TALLAWONG STATION
PRECINCT SOUTH
SSD 10425

RESPONSE TO SUBMISSIONS

DEICORP PROJECTS (TALLAWONG STATION) PTY LTD

January 2021

Views from Sun
Views from Sun_11am

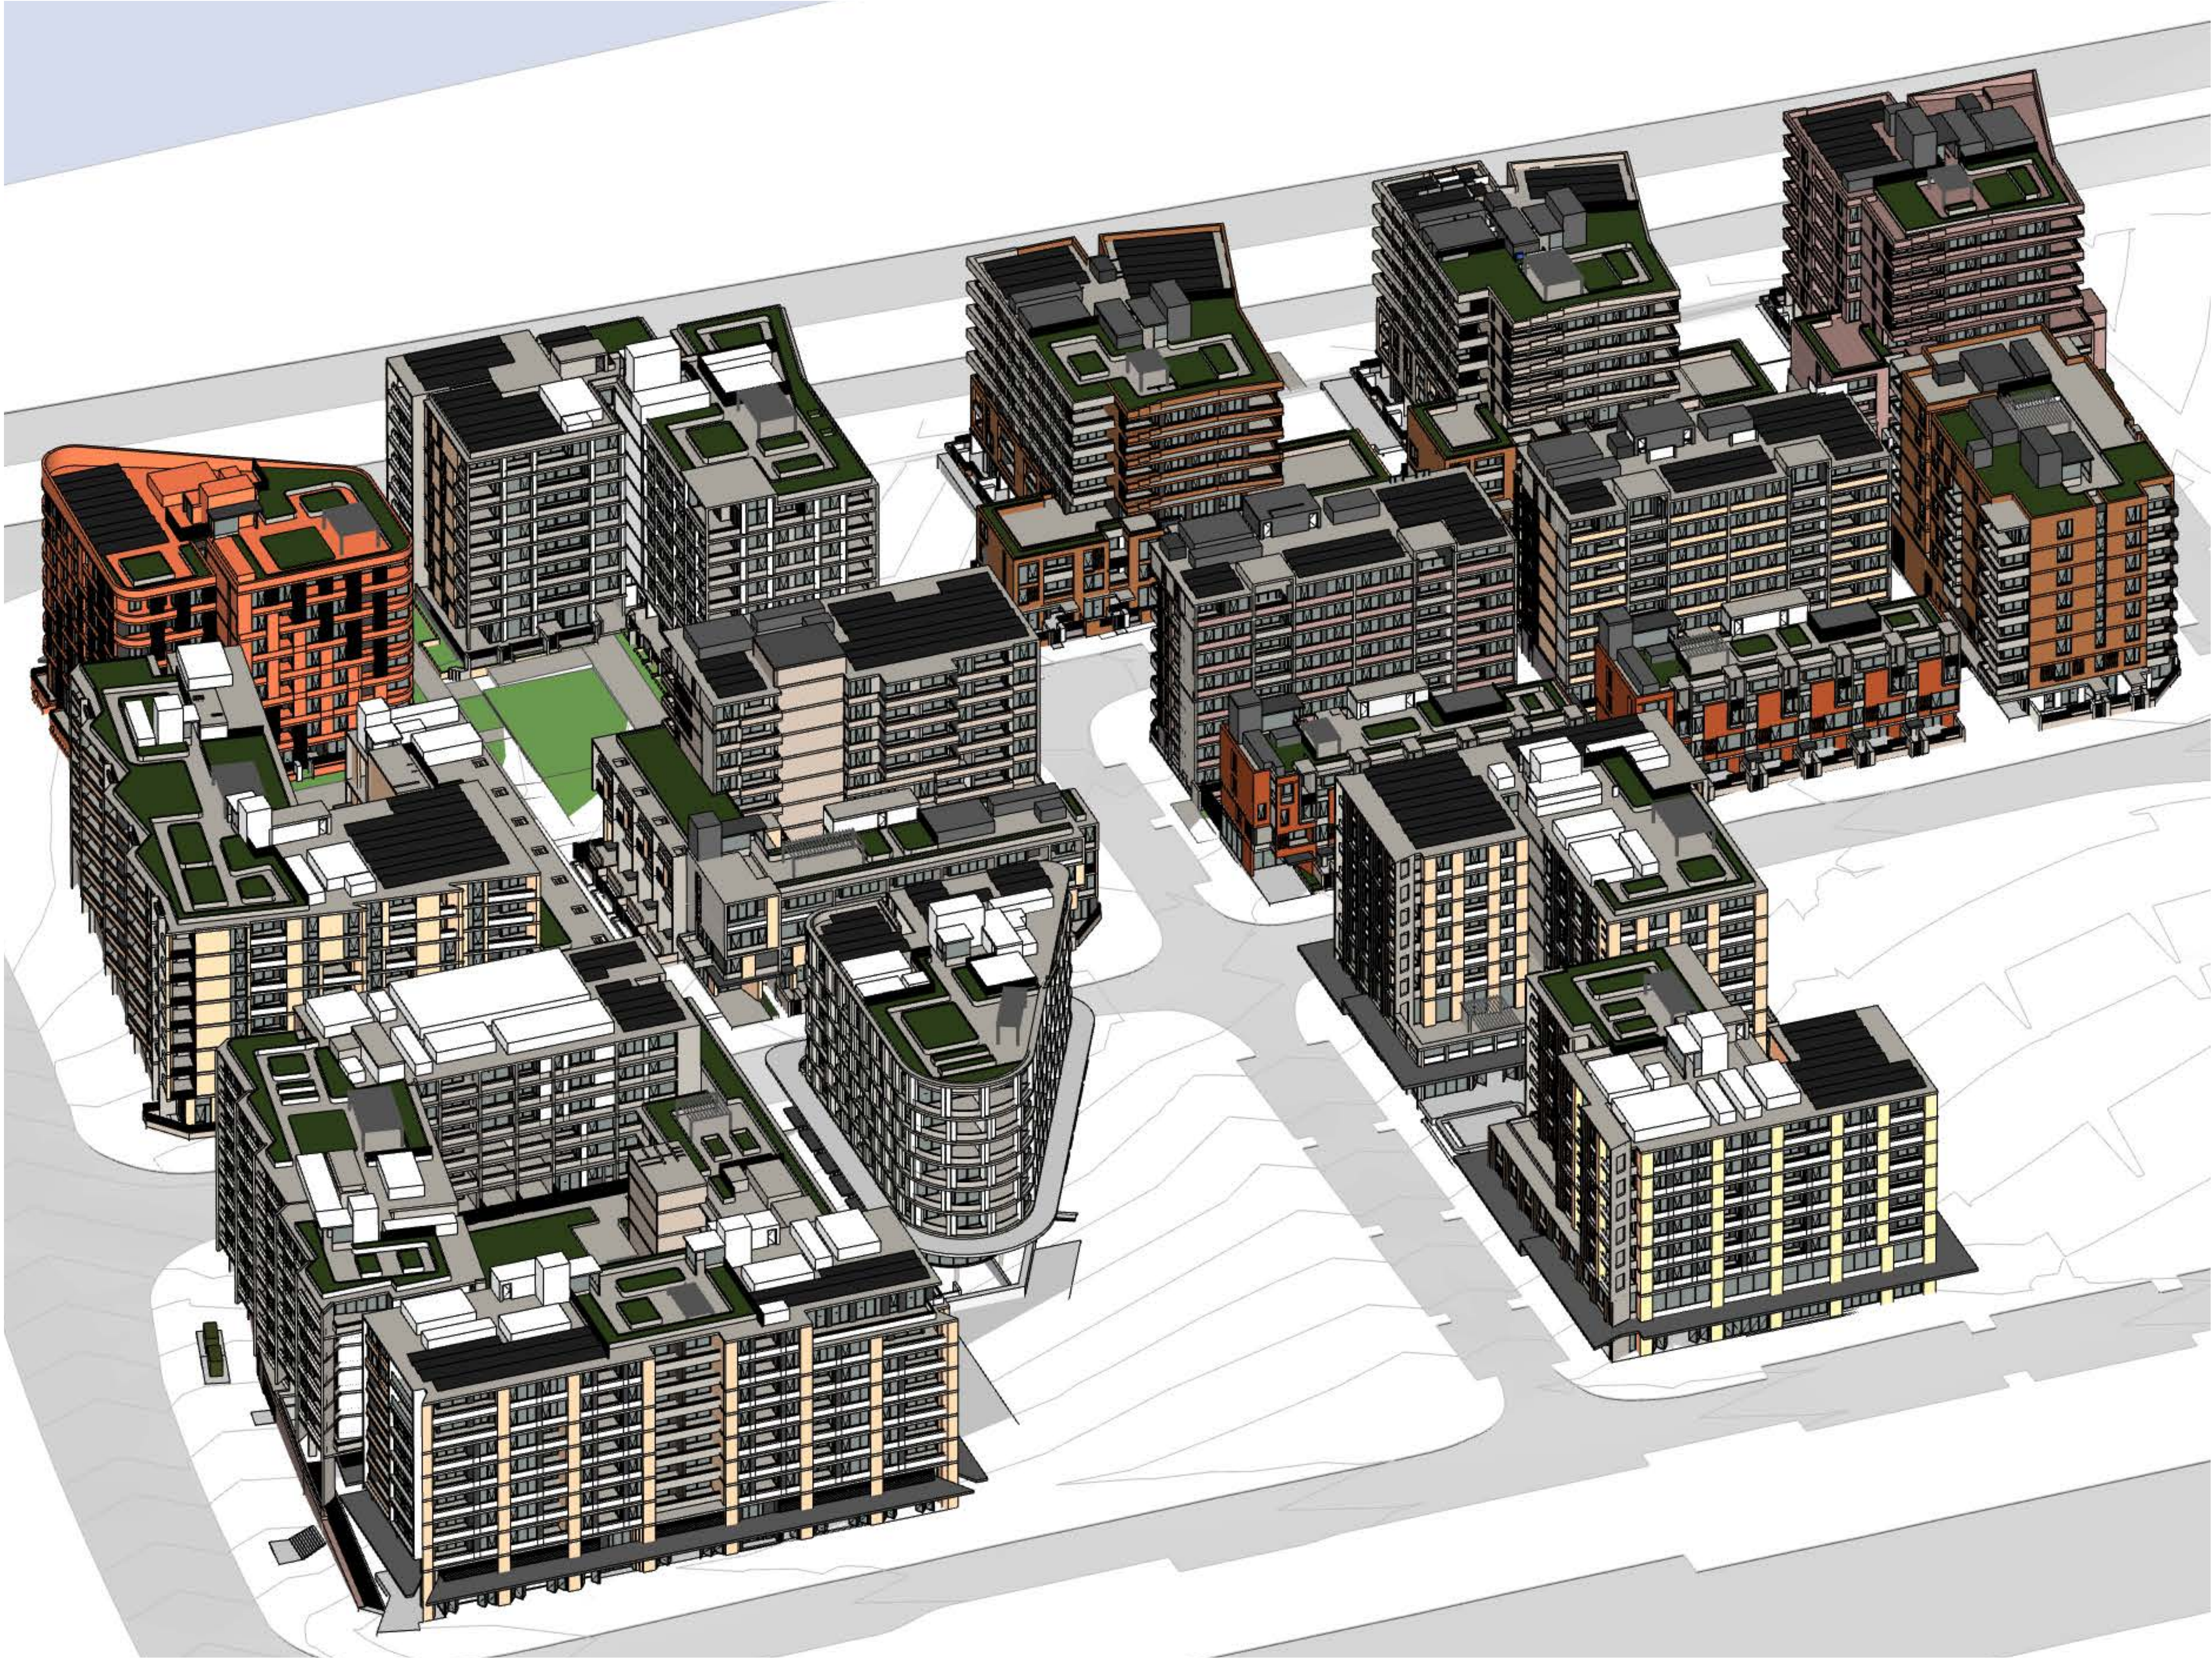
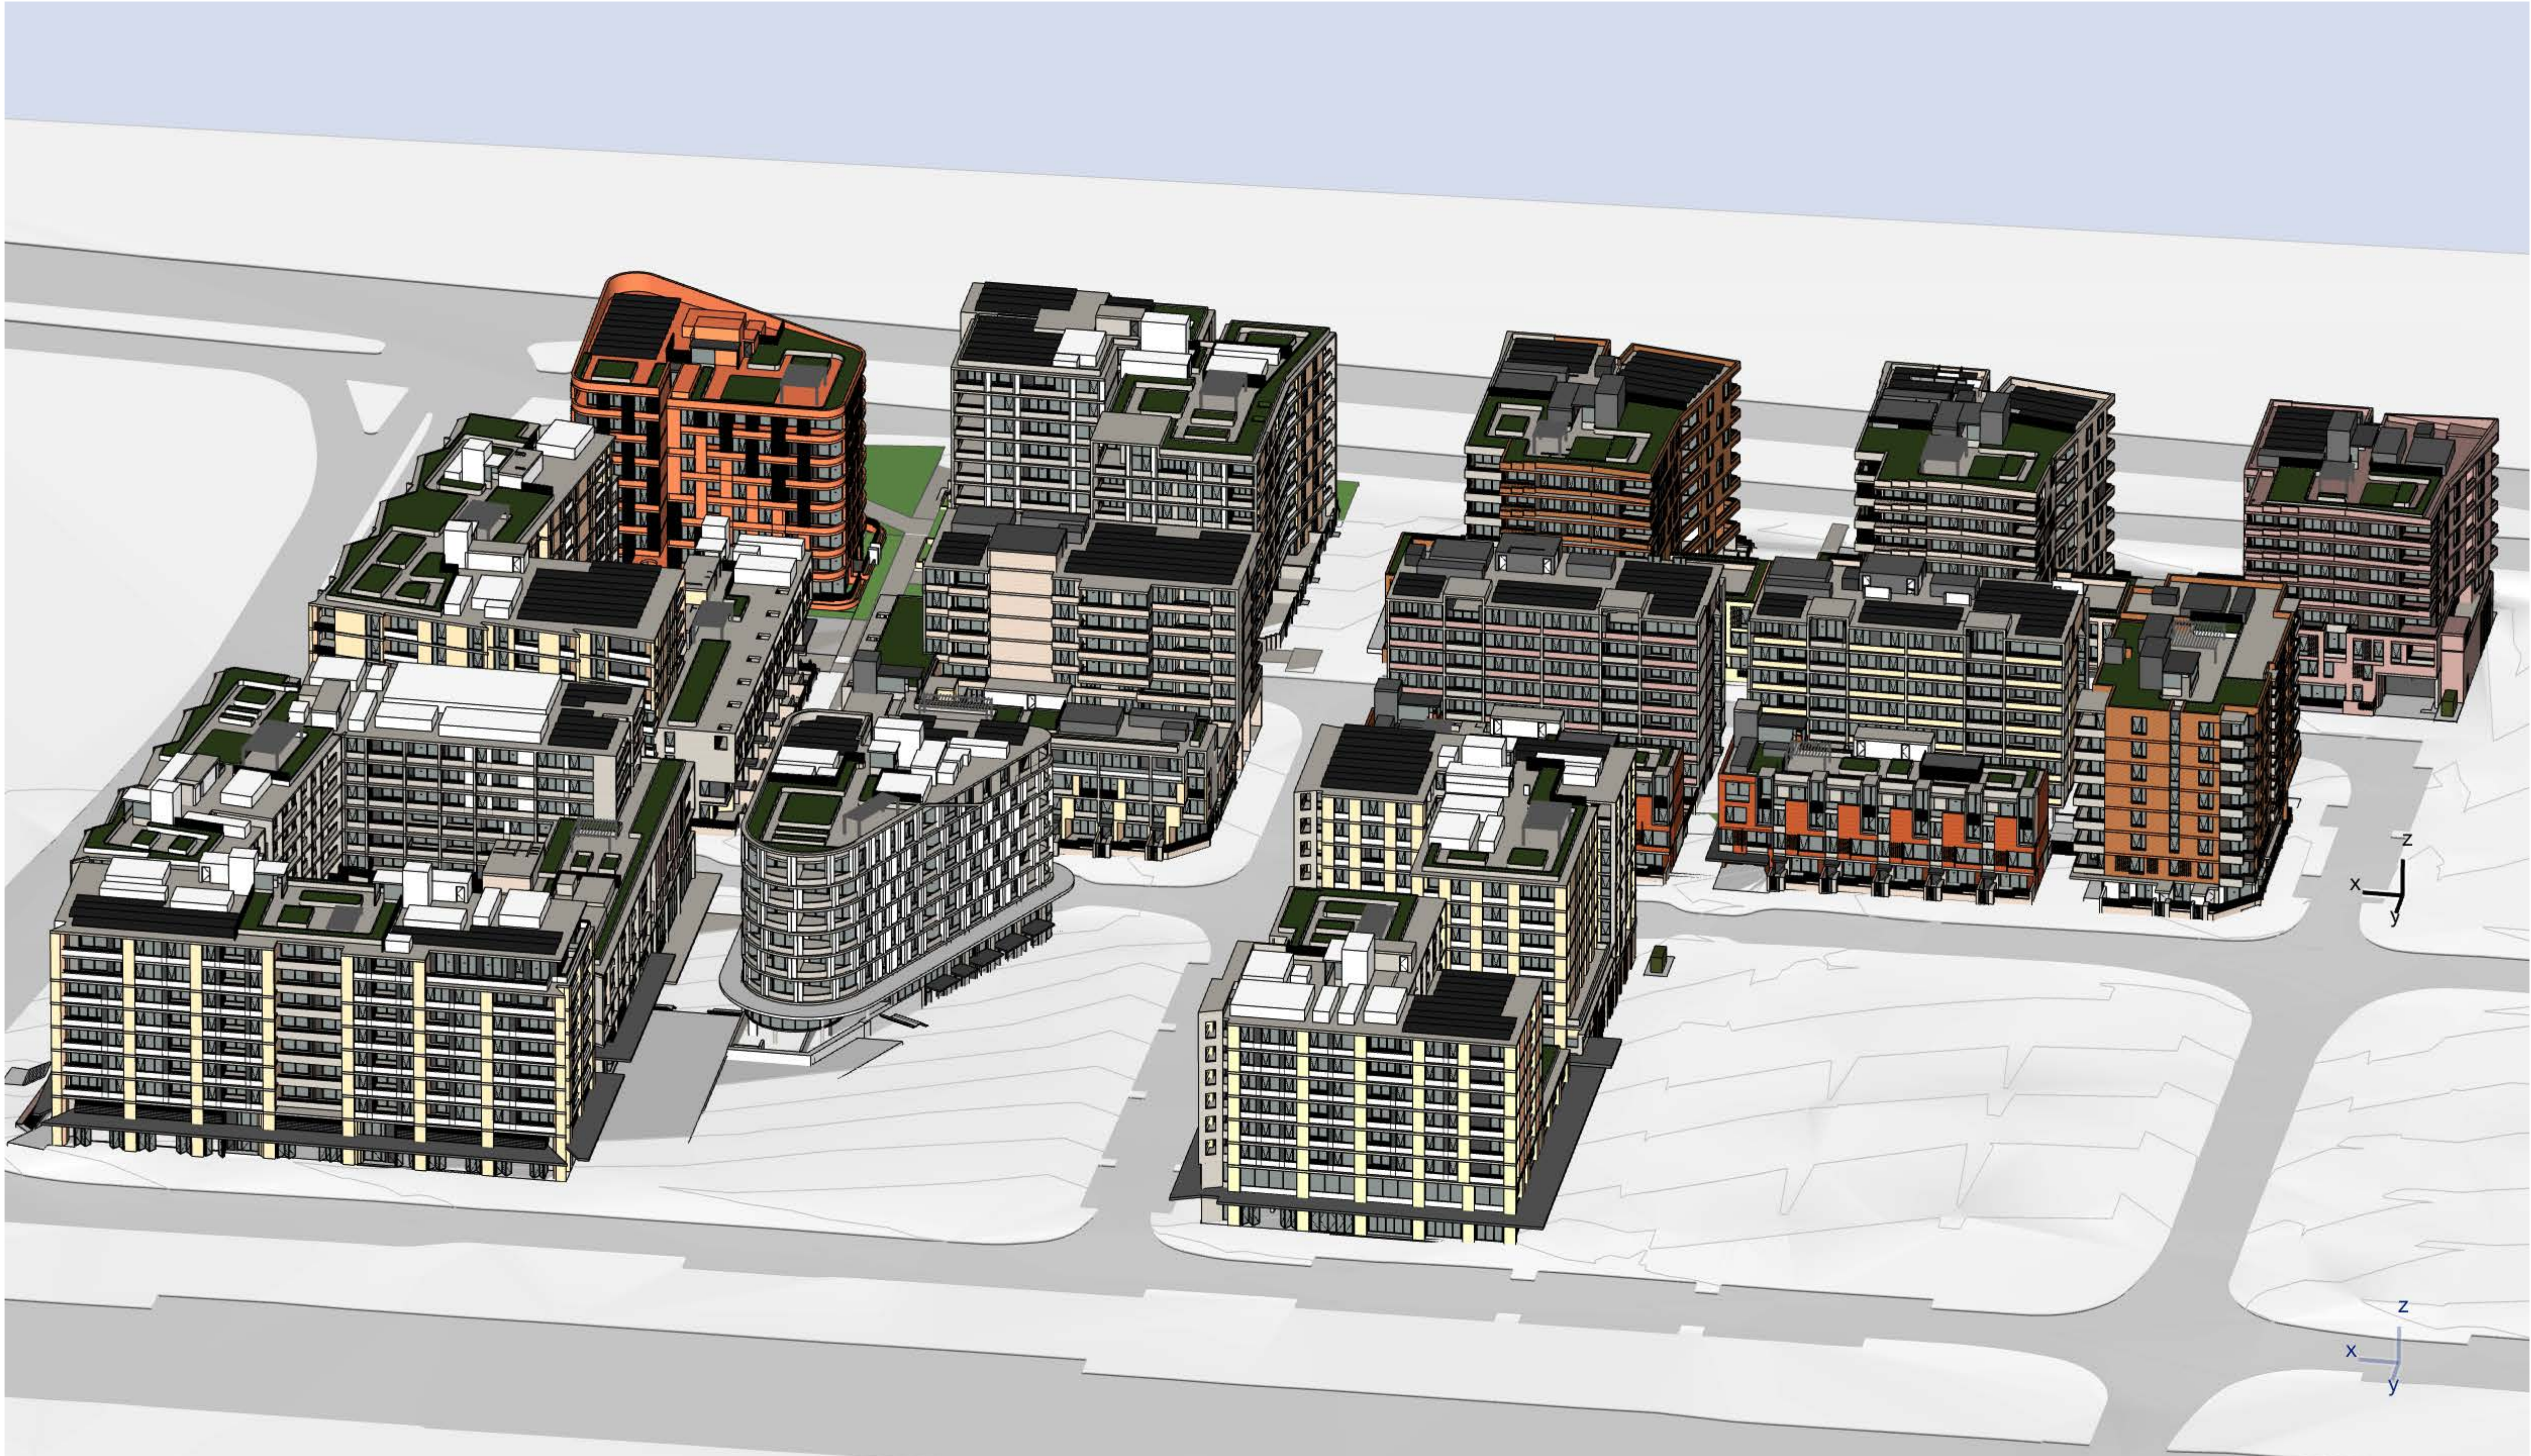
| <p><i>b. configure buildings to distribute density and building height of the precinct with consideration to improving solar access to apartments, communal open space and the public realm.</i></p> | <p>Sutherland & Associates Town Planner</p> <p>The Concept Plan approval has established a built form framework which achieves an optimised outcome in relation solar access to apartments, communal open space and the public realm. The proposed modifications to the Concept Plan in fact improve upon this by reducing shadow impact to the nearest sensitive properties at The Ponds across Schofields Road. In relation to shadow impact to open space, whilst there is some increased shadow to the publicly accessible park, due to the location of the publicly accessible park at the northern end of the site it still enjoys extensive solar access and the majority of the park receives solar access from 10.30am to 3pm on 21 June. This submission is accompanied by sun-view diagrams and shadow diagrams which demonstrate the achievement of the solar Design Criteria of the Apartment Design Guide.</p> <p>Turner Architect</p> <p>The following attached document</p> | <p>Appendix 9</p> |

| | <p>demonstrates solar access to apartments, communal open space and the public realm: ‘Views from Sun’ (DA-715-001 – DA-715-007) The following attached documents demonstrate the ADG solar access compliance for apartments: ‘18095_Development Schedule’ ‘Solar and Cross-Ventilation Diagrams’ (DA-720-010 – DA-720-110).</p> | |
